FIRST WRITTEN QUESTIONS: RESPONSE OF HISTORIC ENGLAND

1.13.4 Historic England asserts in its relevant representation [RR-002] that Tilbury Fort is of exceptional significance and that the impact of the Proposed Development on its setting would cause severe harm to its significance:

REVISED LIMITS OF DREDGING PLAN
TILBURY 2 DOCUMENT REF: POTLL/T2/EX/45

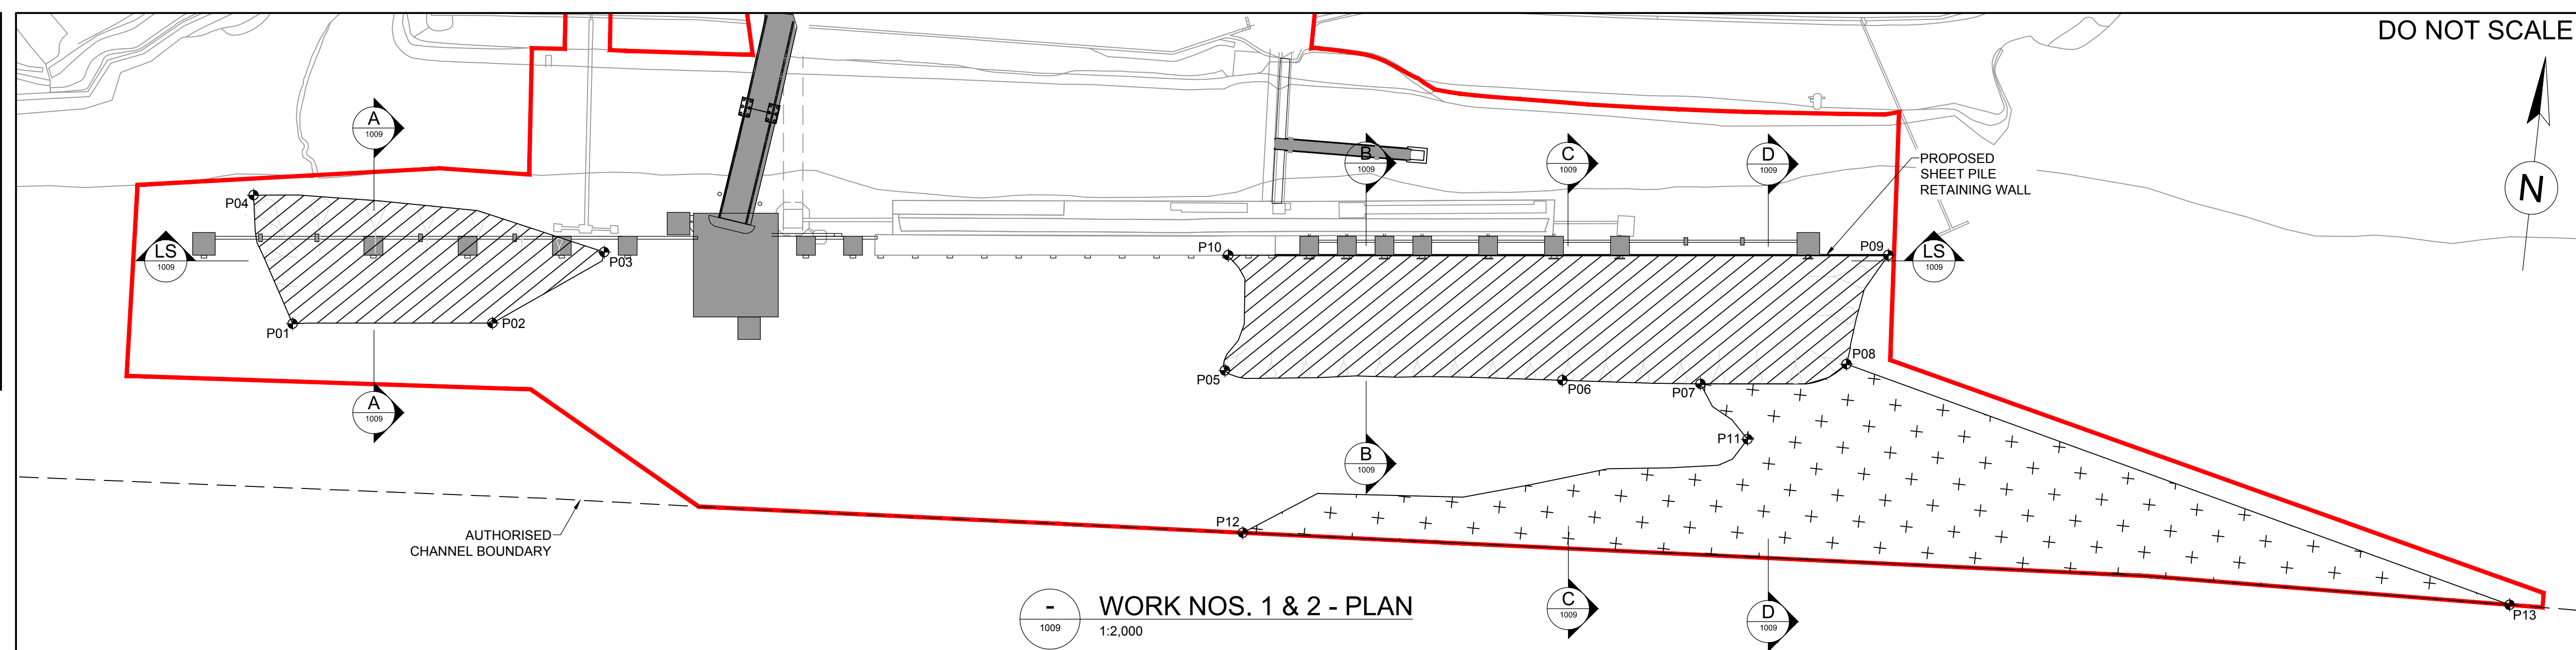
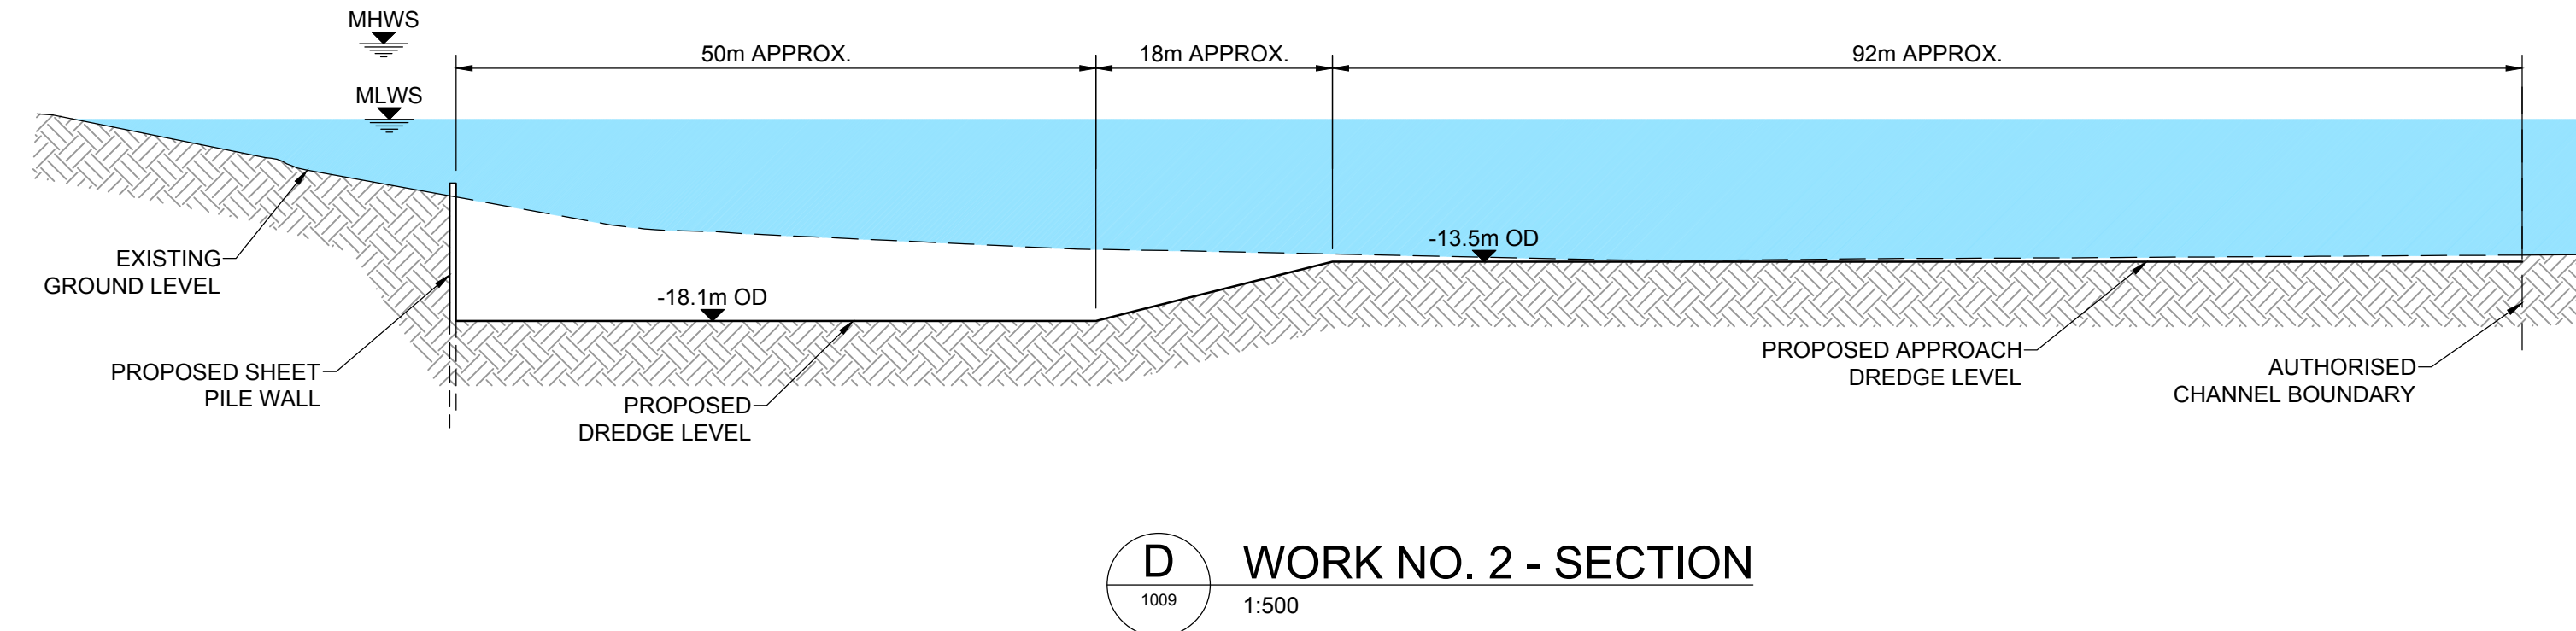
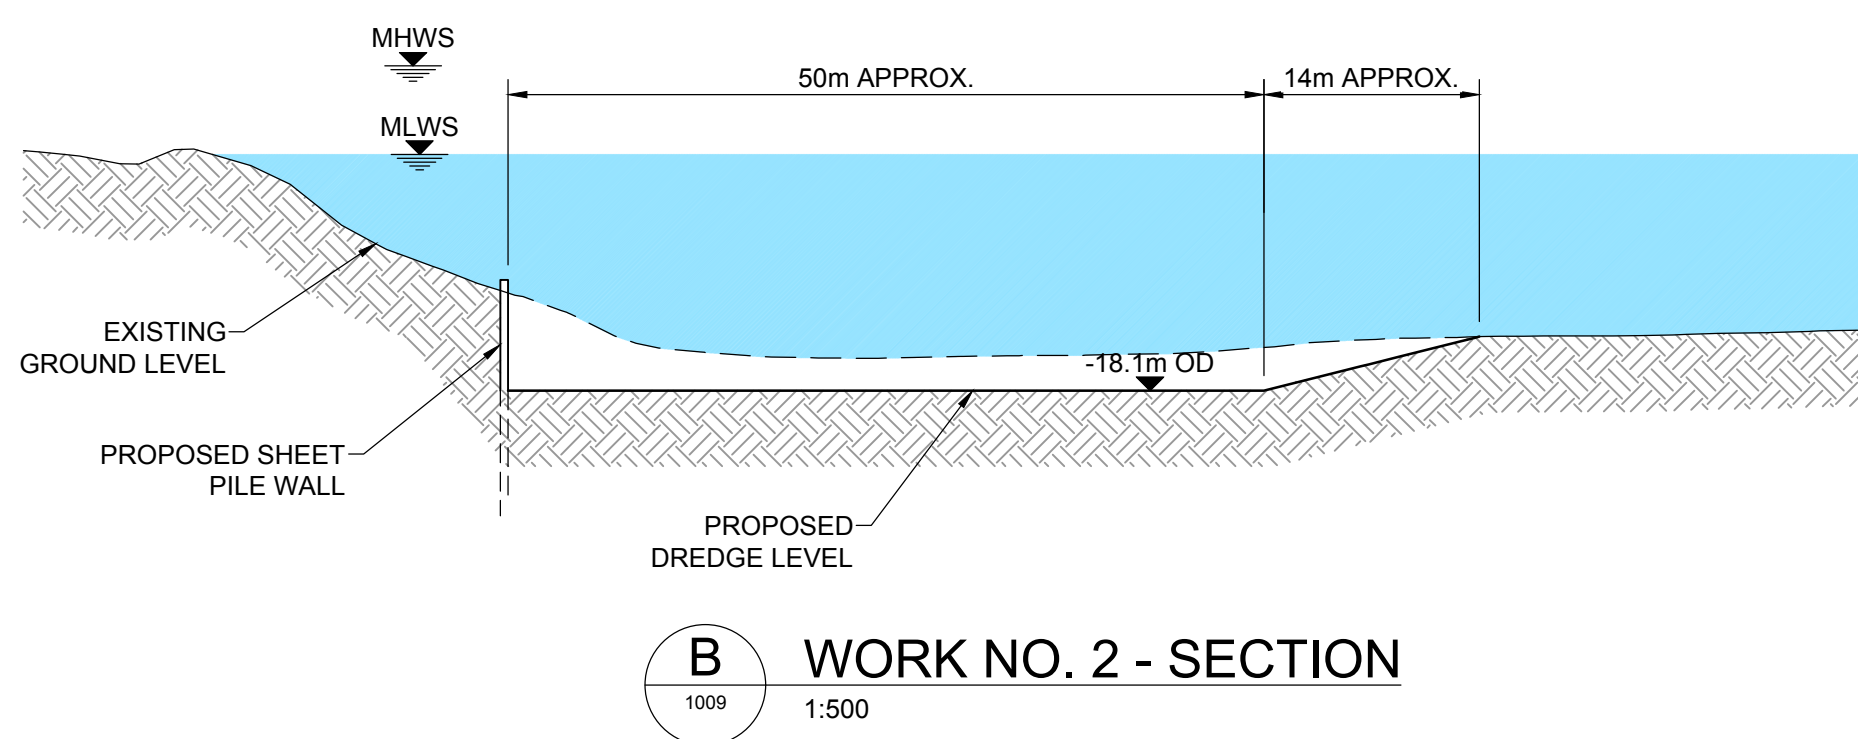
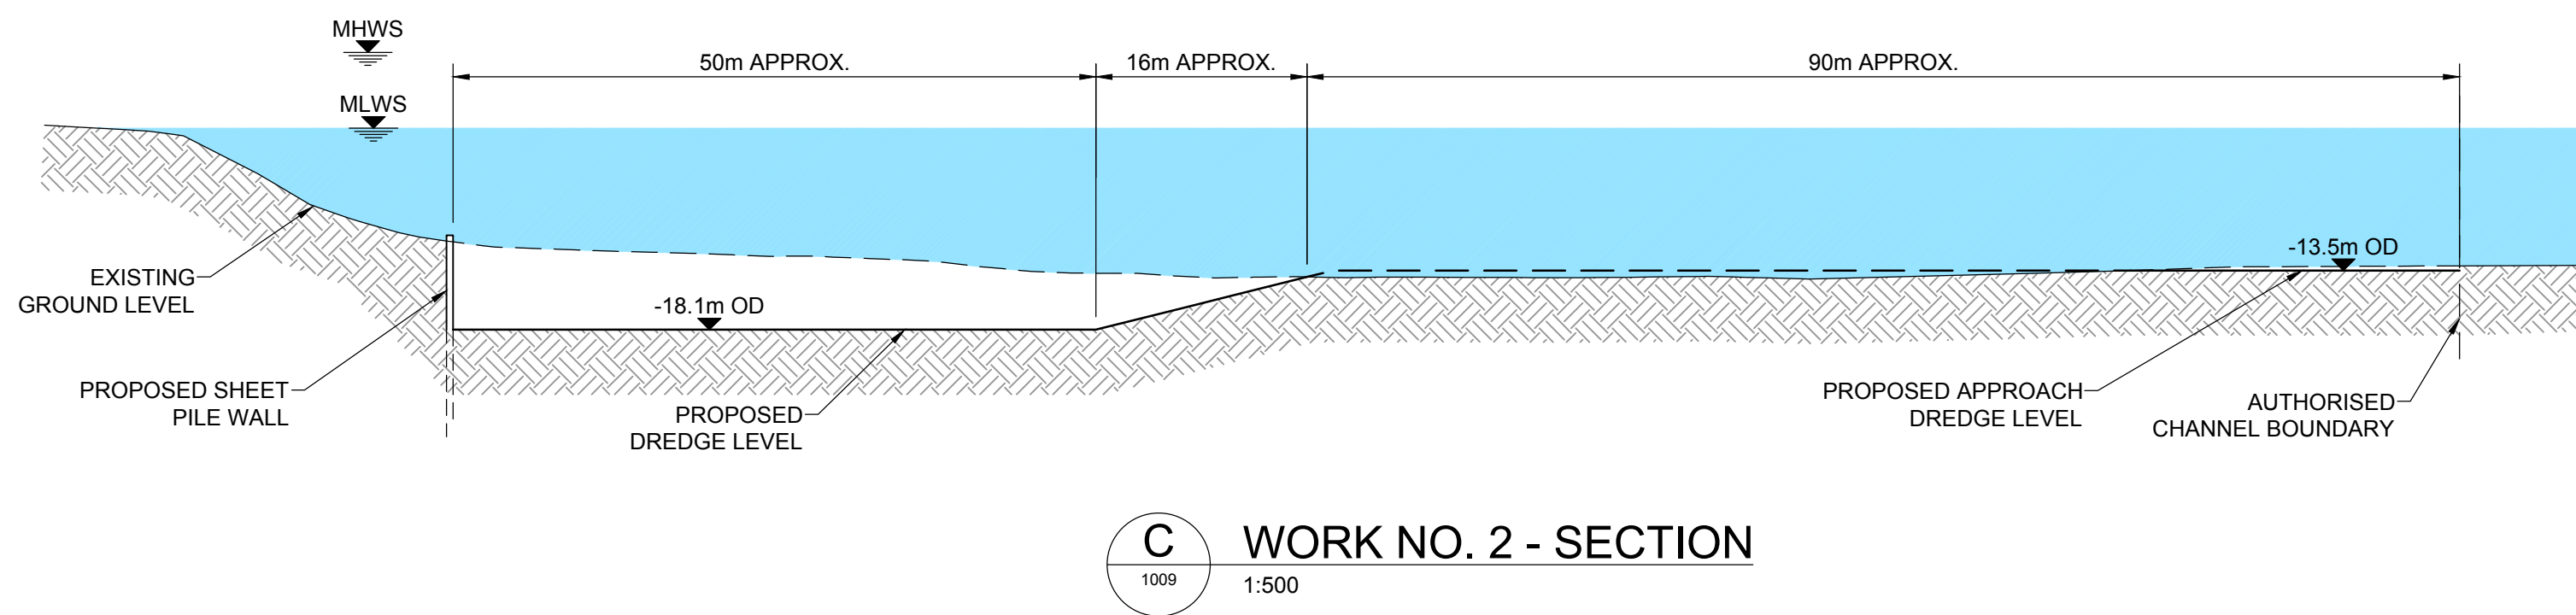
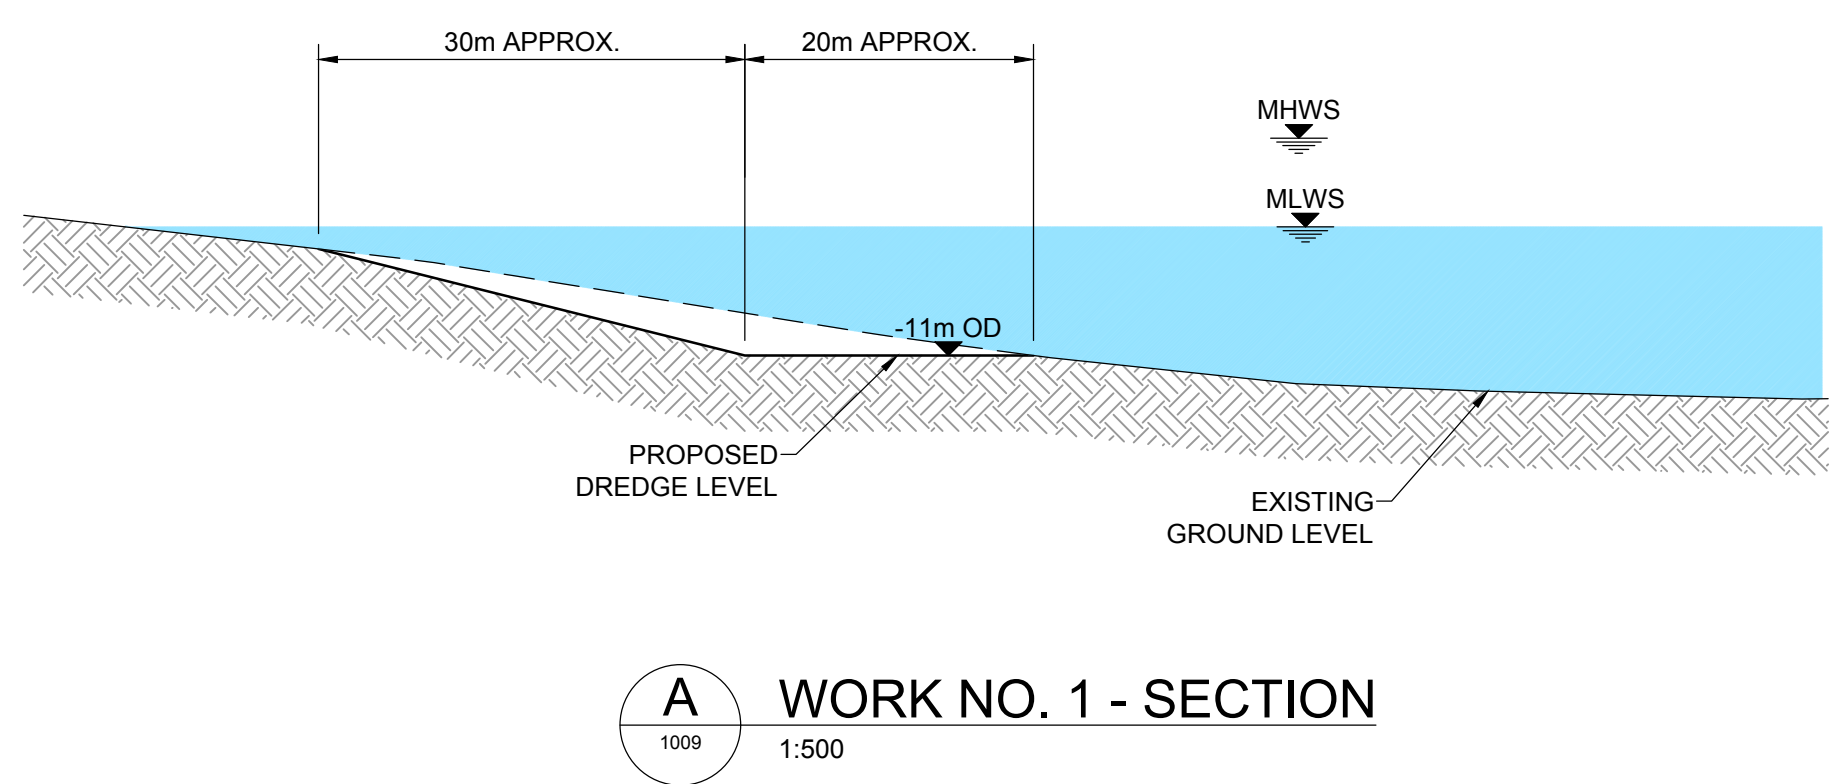
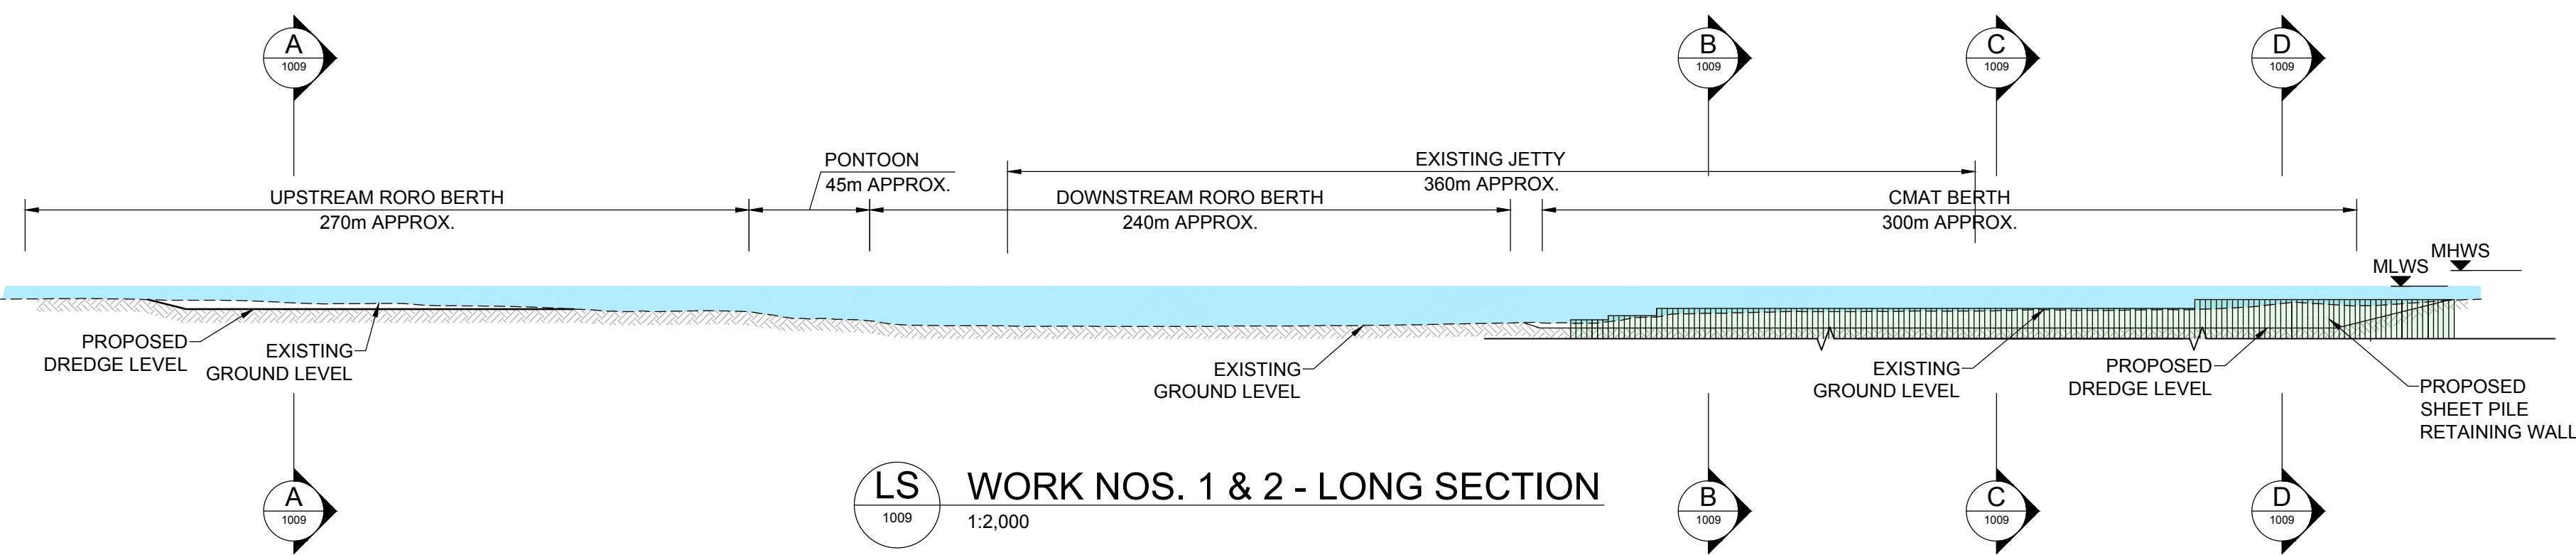
To summarise the present outline detail provided by the Applicant regarding the proposed capital dredge programme in the vicinity of a bulk handling berth and a western RO-RO berth. We understand that the dredge pockets are to be dredged to -15 m Chart Datum (CD) at the bulk handling berth, and -7.9 mCD at the RO-RO berths. Presently, the minimum pre-dredge depths in these areas are approximately -8.0 mCD and -3.9 mCD respectively.

6) When determining any possible negative impact associated with this proposed dredging we must consider the associated capital dredging programme which downstream of the CMAT jetty will necessitate lowering the riverbed by approximately 1m to 5.8m. The RoRo berthing pocket (next to the western end of the existing jetty and around its westward extension) will require dredging to lower the riverbed by approximately 0.10m to 2m and that the adjoining approaches to the berth pockets will also be dredged. However, Section 2.8 (Layout of proposed works simulated) within the HR Wallingford report describes the basis for the computational

modelling of “Up to 4 m of dredging is required to bring the western berth to the target depth; about 7 m of dredging is required to bring the eastern end of the berth area adjacent to the existing jetty to the target depth. Additionally up to 2 m of dredging would be needed to provide the dredged approaches.” Elsewhere in the report, see section 3.3.2 (result) it states that at the eastern end of the bulk berth “...dredging, up to 6m below the present bed level so notable infill would be expected here.” These different descriptions of the proposed capital dredging programme do not appear to tally with other detail we have seen in the submitted Application and is a matter that should be clarified by the Applicant.

7) The report is clear that dredging the berth pocket “...to several metres below the natural regime depth in an area which is known to be sensitive to sedimentation is likely to lead to the dredged areas being subject to ingress of sediment.” The issue therefore is whether this ingress of sediment might be from associated with drawdown of foreshore adjacent to Tilbury Fort. For example, Figure 3.5 seems to suggest that loss of sand infill will occur extending west to Tilbury Fort and Figure 3.11 seeming to show modelled scour at the extreme western end of the proposed development.

10) Section 7.3 states that "Alternatively the overlying soft silts and finer sands found in the boreholes could be removed by water injection dredging (WID) with any stronger or coarser sediment found at depth removed by backhoe." We therefore request that attention is directed at understand how a combination of dredging techniques might affect sedimentary dynamics and therefore what the worst case scenario might be in reference to identified sensitive receptors such as Tilbury Fort and seabed anomalies of possible archaeological interest. We note that the report does mention the use of cutter suction dredger (loading into barges) or trailer hopper dredger both of which would seem to merit more attention given the statement made in Chapter 5 (as referenced above).
